Appeal Decision

Appeal Ref: APP/T2350/H/13/2196097

Green Solicitors, 79 King Street, Whalley, Clitheroe BB7 9SW

- The appeal is made under Regulation 17 of the Town and Country Planning (Control of Advertisements) (England) Regulations 2007 against a refusal to grant express consent.
 - The appeal is made by Mr Ian Proctor (Green Solicitors) against the decision of Ribble Valley Borough Council.
 - The application Ref 3/2012/1079, dated 21 November 2012, was refused by notice dated 7 February 2013.
 - The advertisements proposed are 2 No. signs, internally illuminated, matching materials.
-

DRAWING TITLE
EXISTING ELEVATIONS & FLOOR PLANS

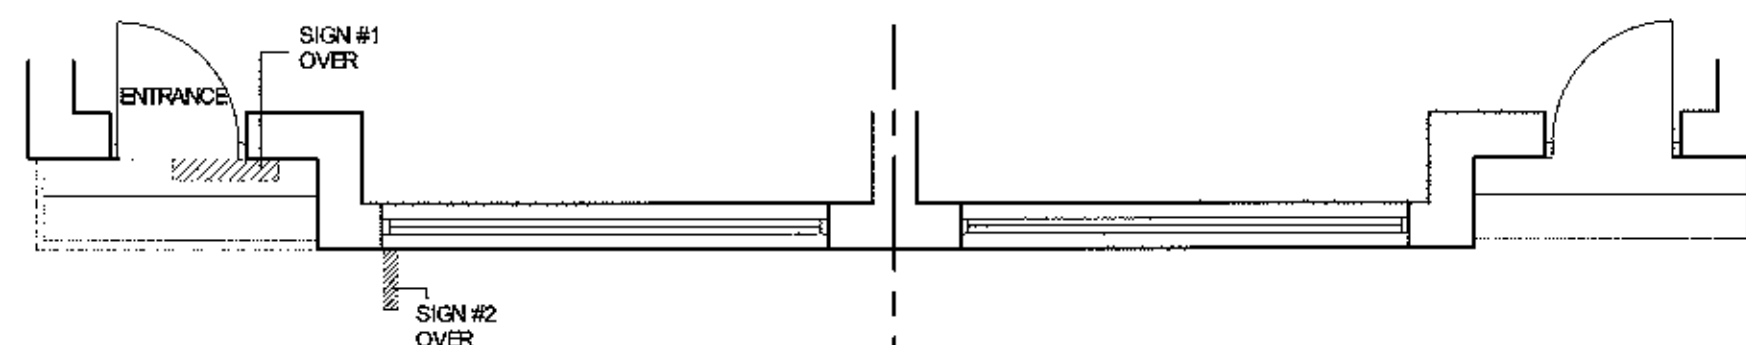
5. The appeal signs, which are already in place, comprise two internally illuminated signs, one attached flush to the recessed front wall and the other a box projecting from the front gable wall immediately above the projecting sign for the ground floor use. Although fairly small, the flush sign partially obscures the attractive banded brickwork and, particularly due to its being internally illuminated, is prominent in views of the terrace from the open space and residential street opposite. The projecting sign is at a particularly high level and, being adjacent to the first floor window, clashes with the architectural composition of the façade and is prominent in views along the street. Its position above another projecting sign adds to, rather than diminishes, the cluttered appearance. Both appeal signs are of modern design and bright metal and coloured vinyl materials, at odds with the traditional character of the terrace. Overall, therefore, they represent incongruous and prominent additions to the building.

7. I accept that there are numerous signs on the appeal and neighbouring properties but the appeal signs, whilst relatively small, are no less conspicuous for that and only add to the visual clutter, particularly due to their height, illumination and prominence. I have not been provided with any convincing evidence that the existence of the adjacent signs should set a precedent for the current appeal. The appellant also draws attention, in a *Historical Merit Statement*, to the number and variety of signs within the conservation area as a whole. However, those other signs occupy a variety of contexts which in almost all cases are not completely comparable to the appeal signs. Each proposal must be considered on its individual merits.

8. Similarly, although a number of signs in the locality are internally or externally illuminated, they do not justify the additional visual impact of the appeal signs. Furthermore, the appeal property occupies a relatively sensitive location, on the edge of the commercial area, facing an open space and dwellings, where excessive illuminated signage is particularly harmful to the character and appearance of the area. Given my concerns about the position, prominence and cumulative impact of the appeal signs within the conservation area, I am not convinced that imposing reasonable conditions specifying a certain level of luminance or limiting the hours of illumination, as suggested by the appellant, would overcome the harm which I have identified.

9. Circular 03/07 advises that, in accordance with the Advertisement Regulations, advertisements are subject to control in the interests of amenity and public safety. The latter is not an issue in contention in this case but I conclude that the signs significantly harm the visual amenity of the area and fail to preserve or enhance the character or appearance of the conservation area.
